March 1, 2013

Memorandum
Department of Planning and Development
Planning Division

RE: C. of O. for # 385 Cumberland Avenue, Shalom House
(Id # 2011-388) (CBL 033 I 009001)

After visiting the site, I have the following comments:

SITE PLAN

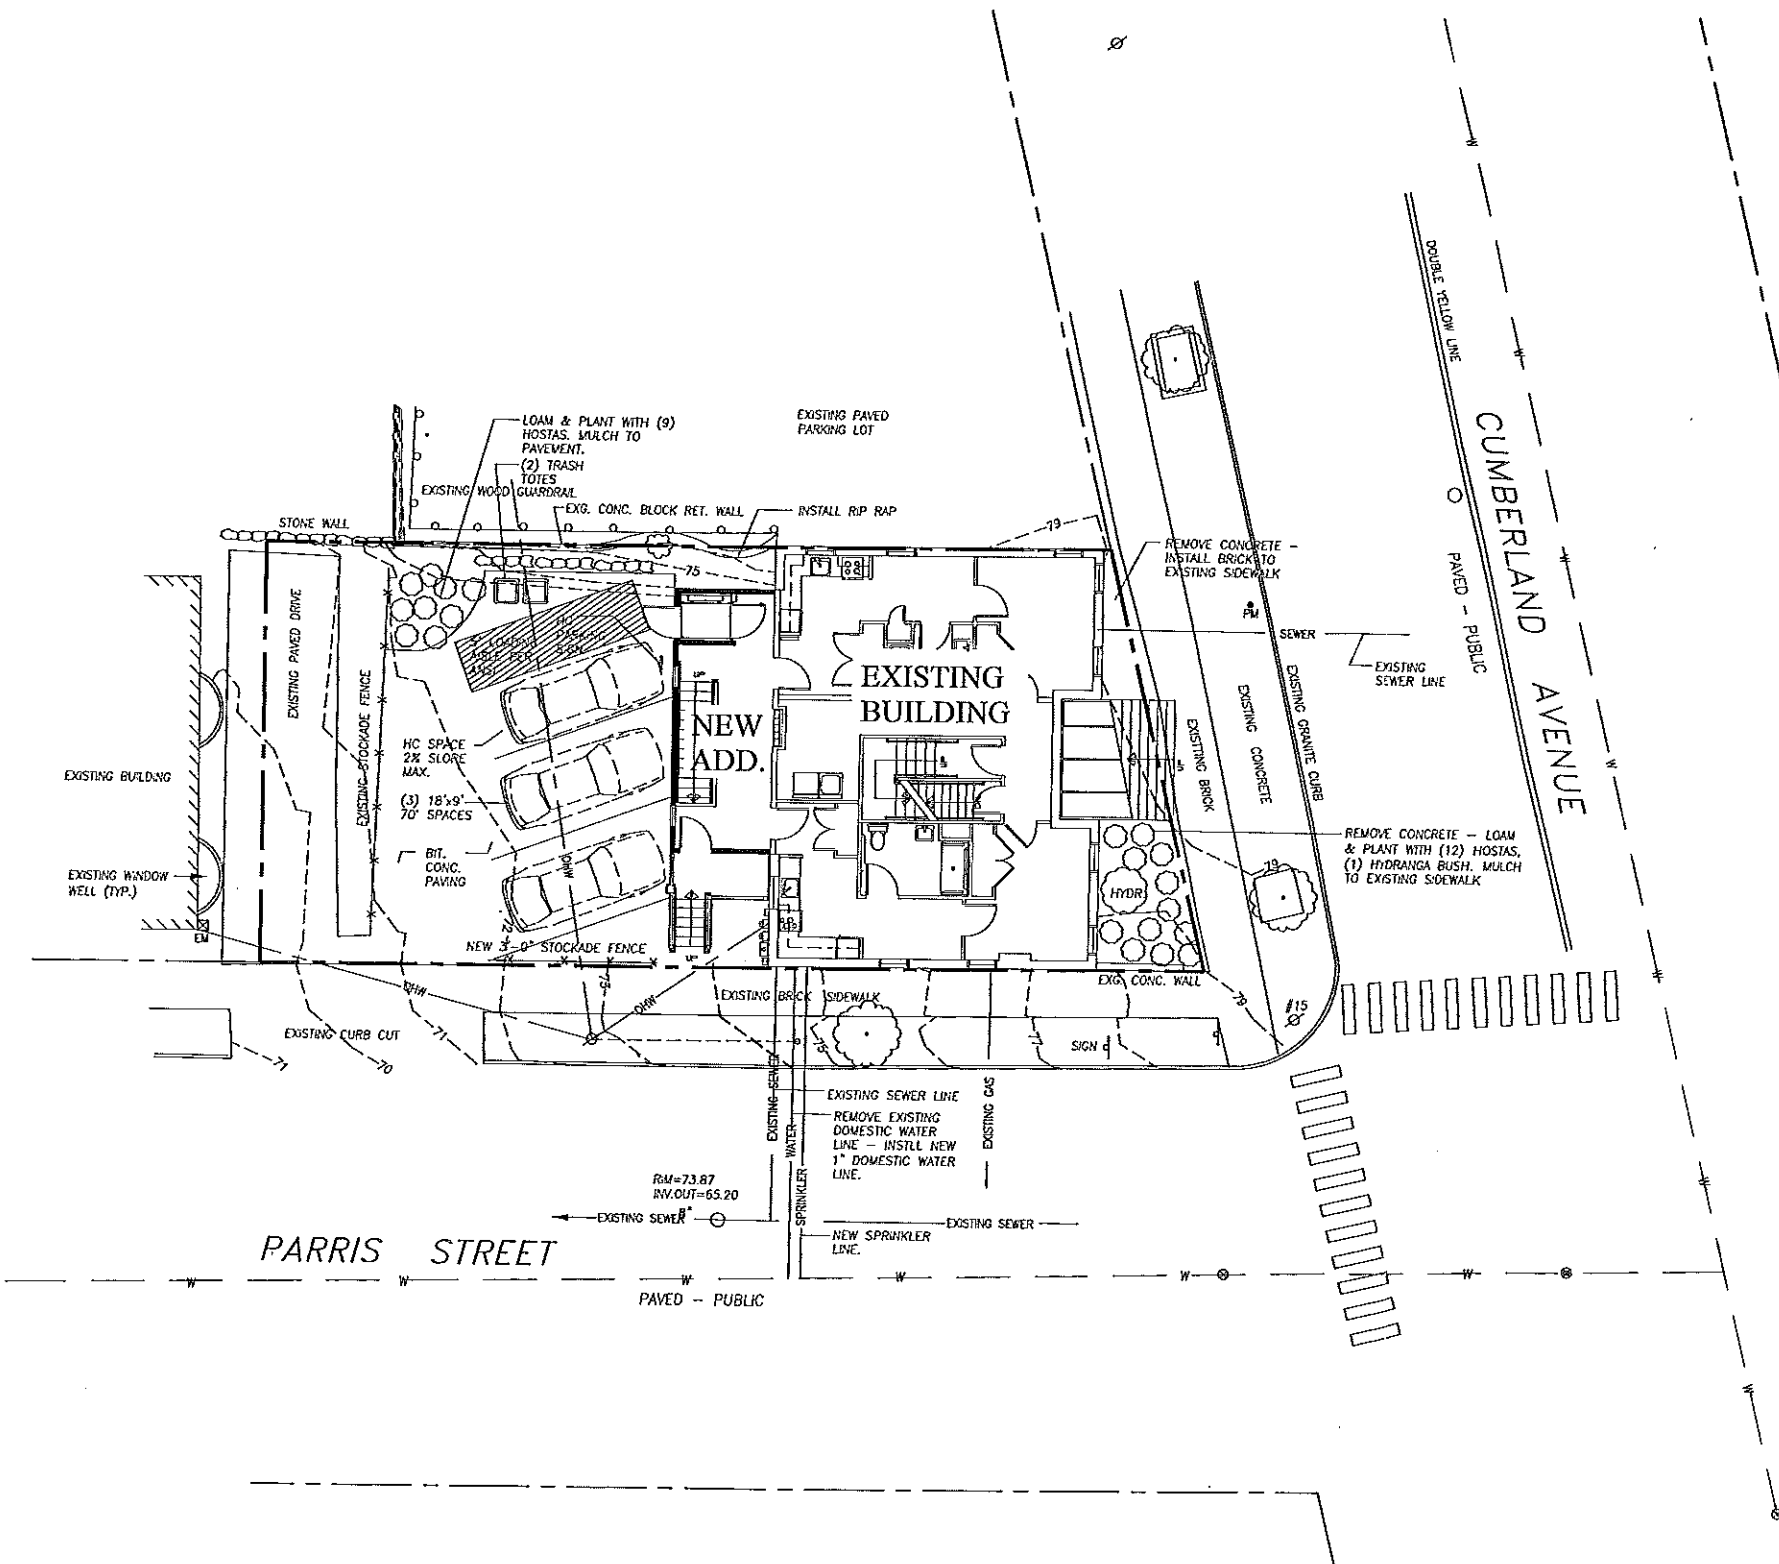
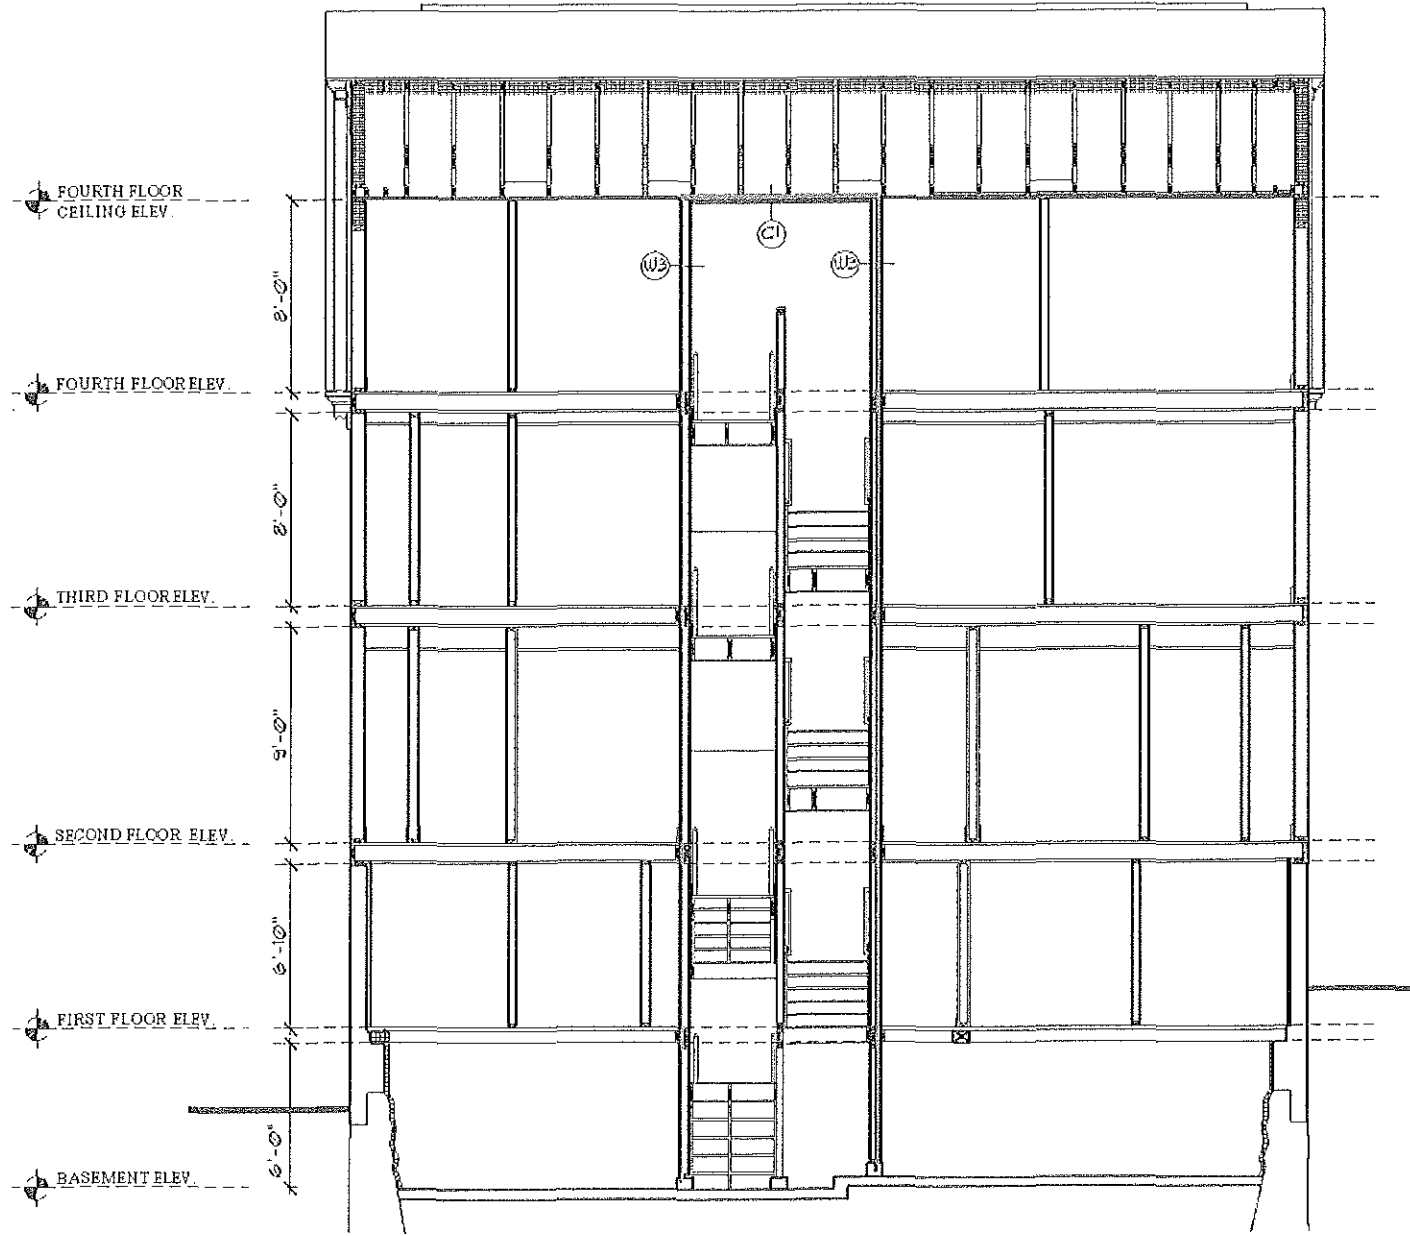
Site work incomplete:

1. Landscaping and plant installations, finish grading, loaming and seeding,
2. Paving and striping,
3. Installation of the 3 foot stockade fence,
4. Riprap installation,
5. Removal of concrete, and installation of brick along the front of the building,
6. Miscellaneous minor site work.
